Inland Rail – Parkes to Narromine EIS – SSI 7475

Annexure - Inland Rail Parkes to Narromine EIS

Figure 7.14 Projected growth in train numbers for Inland Rail

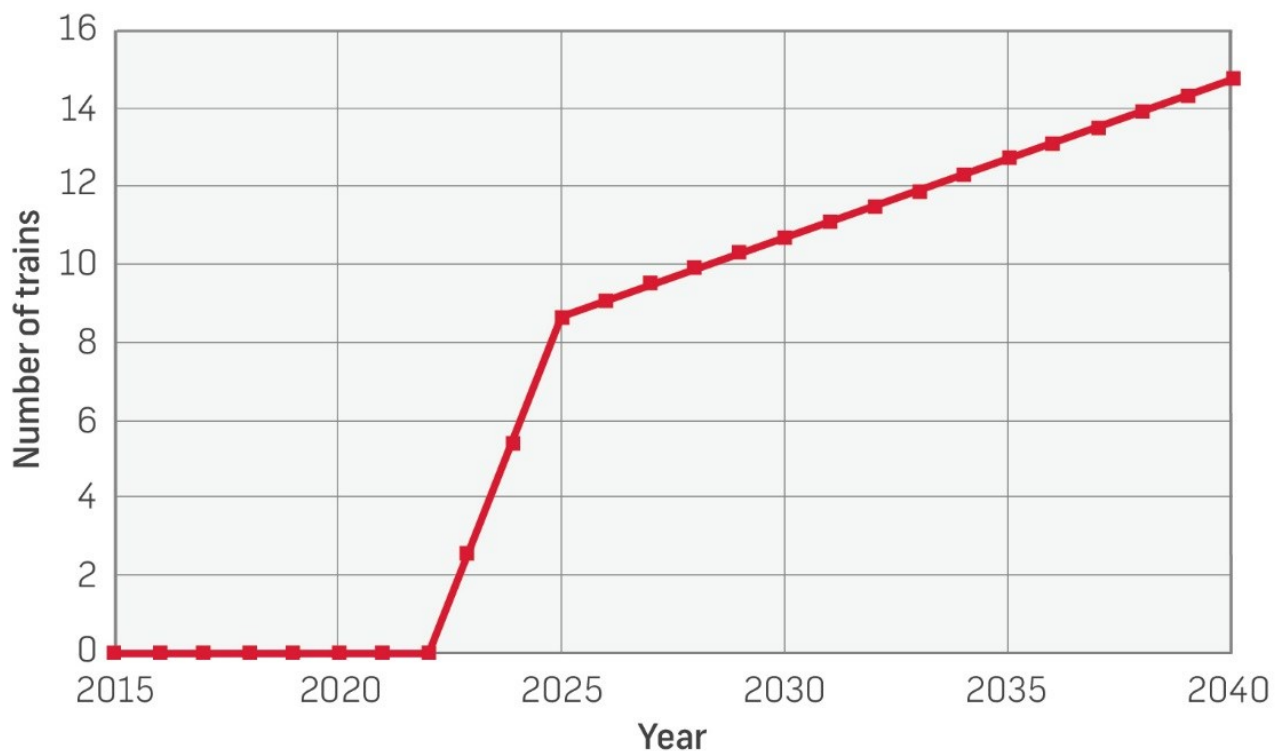
A cumulative assessment of delay on Henry Parkes Way should be presented for the forecast 8.5 trains per day in 2025 or 15 trains per day in 2040. Decelerating trains on the Henry Parks Way Level crossing should be considered (speed potentially below 90km/h) to enter existing and planned intermodal terminals.

**Figure 6.2** *Brolgan Road overbridge options*

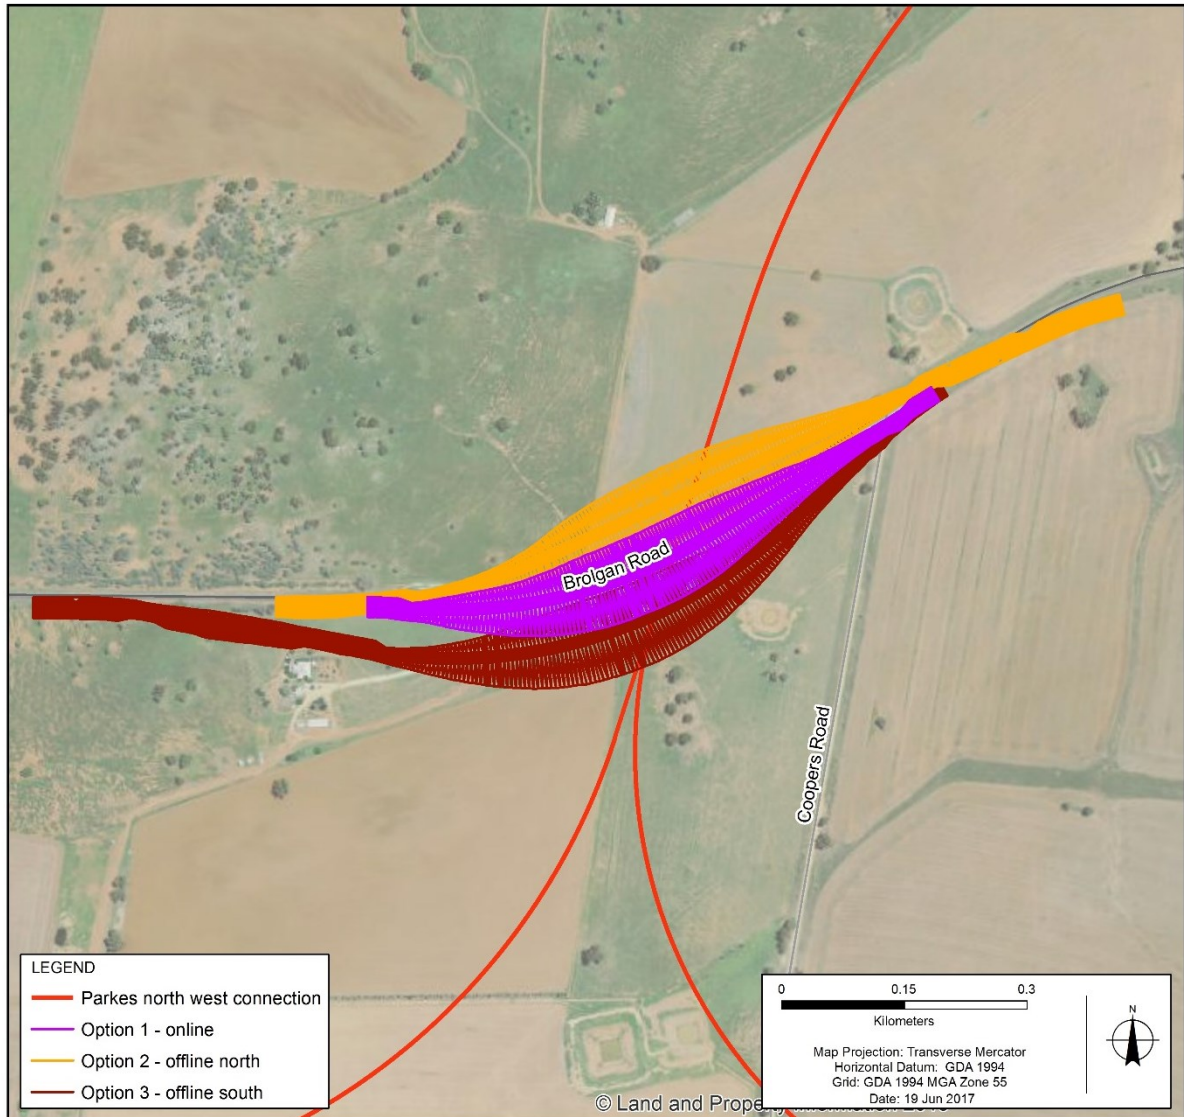
Section 6.3.4 of the Alternatives and Proposal Options assessment report identifies a road over rail bridge as the preferred option for Brolgan Road within the preferred option for the Parkes north west connection to the Broken Hill line.

Similar treatment should also be considered for the Henry Parkes Way intersection at the northern end of the proposed connection. Henry Parkes Way carries significantly higher volume of traffic and includes road trains, which are not permitted on Brolgan Road, at the proposed over bridge location. Henry Parkes Way intersection has limited sight distance in both directions (Brolgan Road would only be limited in one direction) and would carry more rail traffic than the connection line that crosses Brolgan Road.

It is suggested that the proponent undertakes a comprehensive assessment of the existing crossing on Henry Parkes Way given the forecast change in rail operations to assess the appropriate design for crossing (grade separated, active protection, active protection with booms etc). The method used should be agreed with TfNSW prior undertaking the assessment.
